REQUEST

Current Zoning: N1-D (Neighborhood 1-D)
Proposed Zoning: MUDD-O (HDO) (Mixed-Use Development District, Historic District Overlay)

Approximately 3.23 acres located on the northeastern corner of the intersection of West Boulevard and Mint Street.

PLANNING STAFF REVIEW

RZ - 200

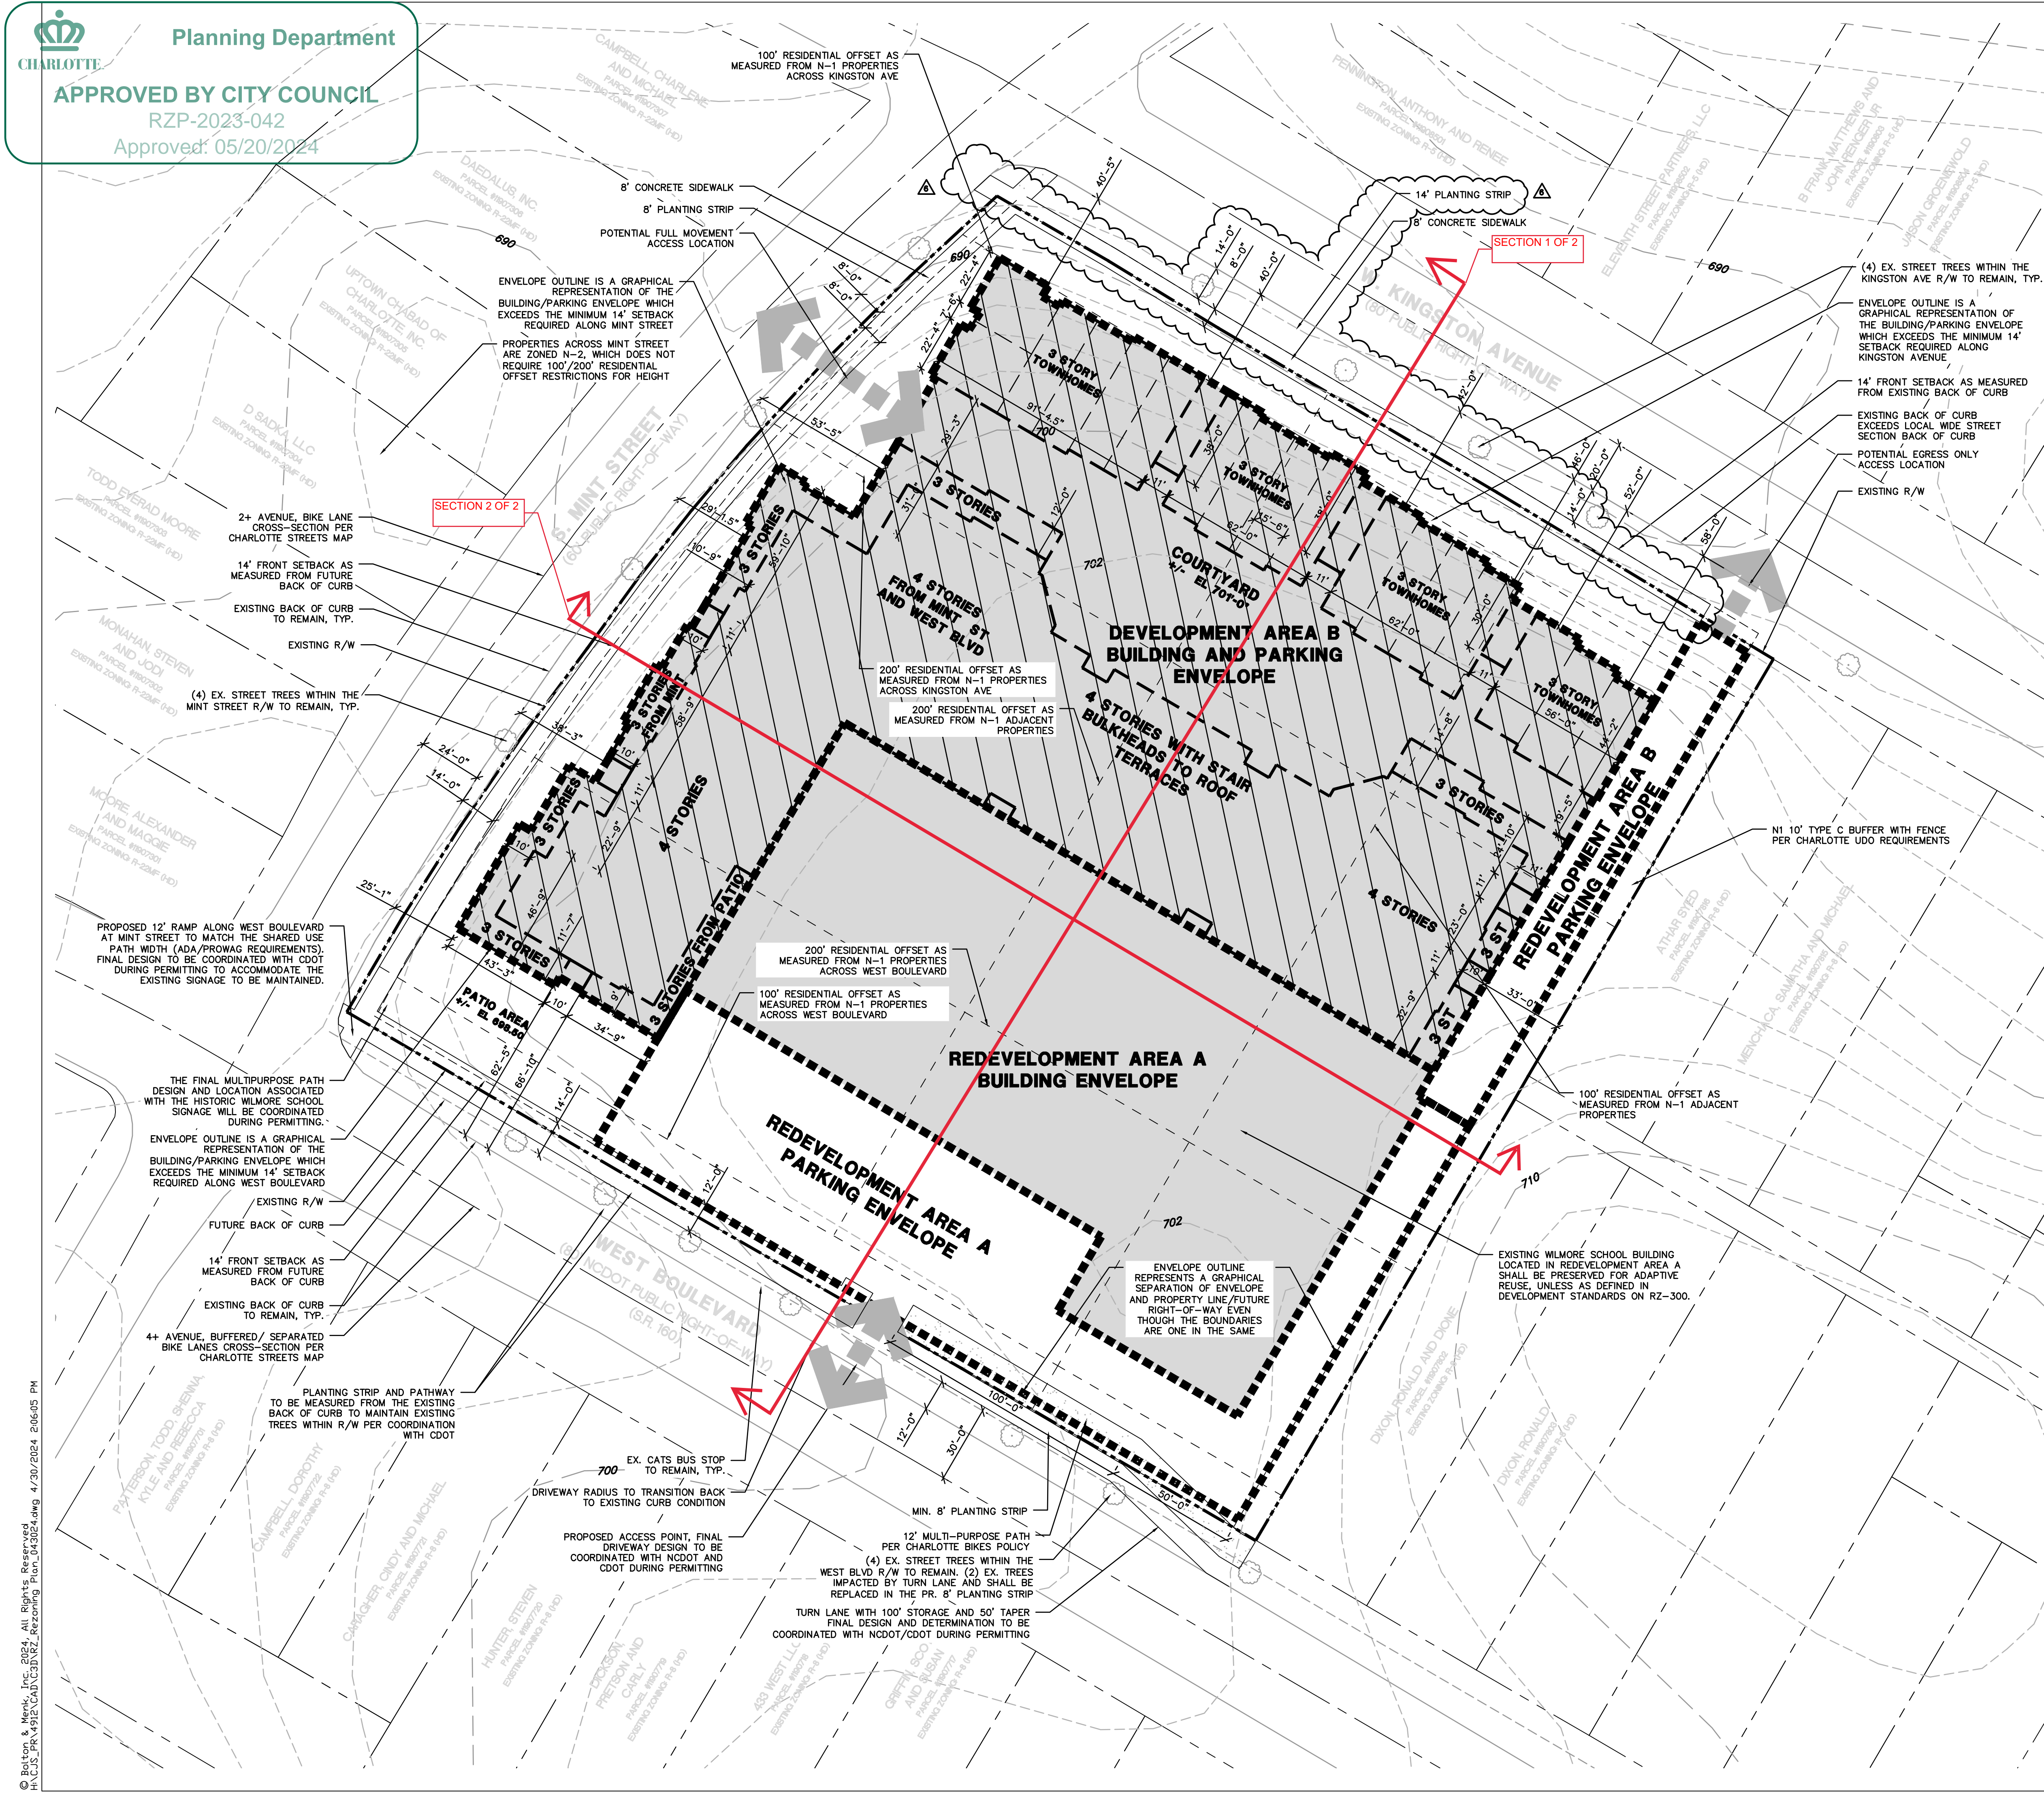
1. Illustrate a proposed 12' ramp along West Boulevard at Mint Street to match the shared use path width (ADA/PROWAG requirement). **ADDRESSED**

5. ~~Revise site plan to show West Kingston Avenue planting strip as 14' to match HDC plan. ADDRESSED~~
6. ~~Revise South Mint Street cross section to show new building parapet height at 45'3" to match HDC plan. ADDRESSED~~
